From: Sarah Burrow <Sarah.Burrow@arun.gov.uk>
Sent: 20 April 2022 14:29
To: Planning.Responses <Planning.Responses@arun.gov.uk>
Cc: Maria Tomalova <Maria.Tomalova@arun.gov.uk>
Subject: RE: Planning Consultation on: FP/31/22/PL

Engineers Comments Regarding Surface Water Drainage

Application No: FP/31/22/PL

Registered: 28th February 2022
Site Address: 107 Felpham Way Felpham PO22 8QB
Grid Reference: 495833 100238
Description of Works: Construction of a pair of semi-detached dwellings with electric mobility scooter/cycle & refuse storage facilities. This site is in CIL Zone 4 and is CIL Liable as new dwellings.

Project		Land to rear 107 Felpham, Bognor Regis	
Drawing		Sketch Site Plan	
Date	august 2021	Drawn by	
Scales	1:100 @ A1	Suitability	sketch
Doc No	DLS-031-SK-11-B	Revision	C

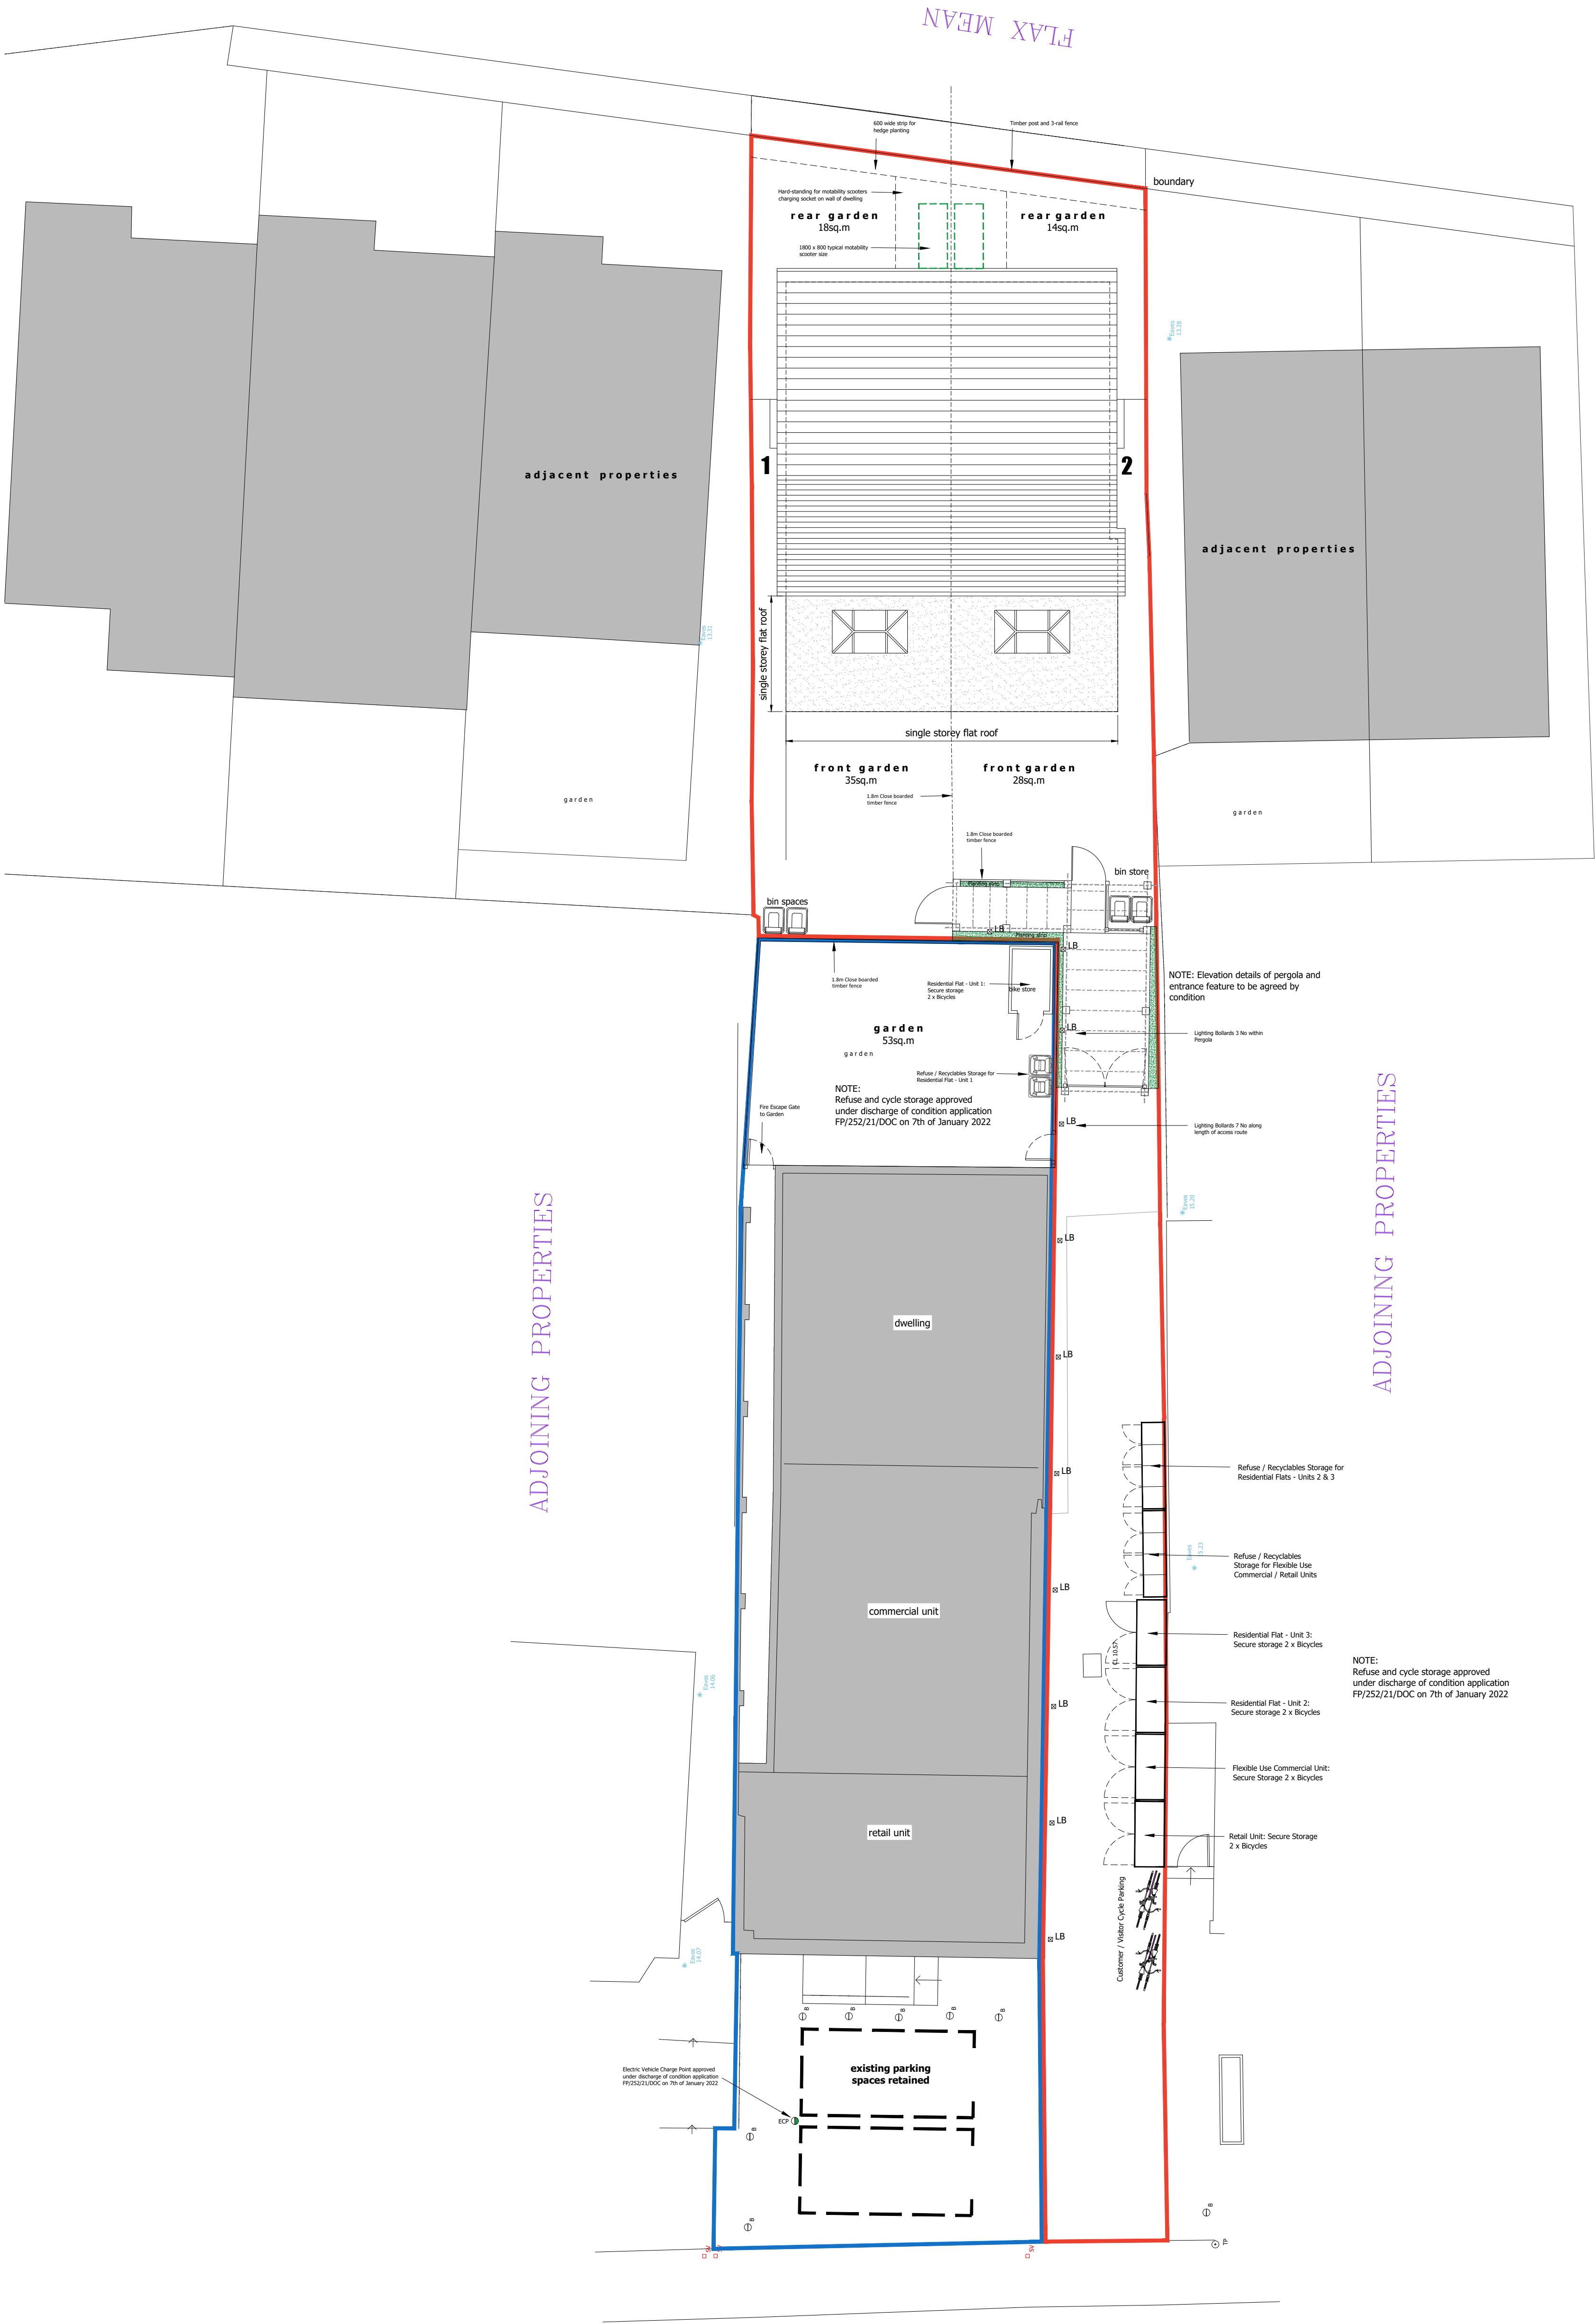
The hierarchy for sustainable drainage must be followed with infiltration fully investigated. Due to the likely ground conditions it is anticipated that if infiltration is viable it will require a large plan area as blanket solutions may be required and 5m easement from buildings to soakaways must be provided, soakaways should also be sited 2.5m from property boundaries. It is clear from the plan showing the distances from the proposed property that soakaways will not fit within the north of the proposed site.

The only potential option to locate infiltration drainage is in permeable paving in the access to the properties. However, this is narrow and bounded on each side by the buildings at 107 and 109 Felpham Way.

To overcome my objection the applicant can attempt to prove that infiltration is not viable on the site by providing infiltration testing completed at any time. However, if infiltration testing is completed outside the winter months and shows infiltration to be viable, then the site investigations will need to be completed in winter to ascertain the design infiltration rate.

We would also need to see a topographical survey to understand the levels of the site, particularly the access, and a drainage layout to show how the site can be sustainably drained in accordance with the adopted WSCC [Policy for the Management of Surface Water](#). Further links to our guidance on surface water drainage are provided in the suggested informative below.
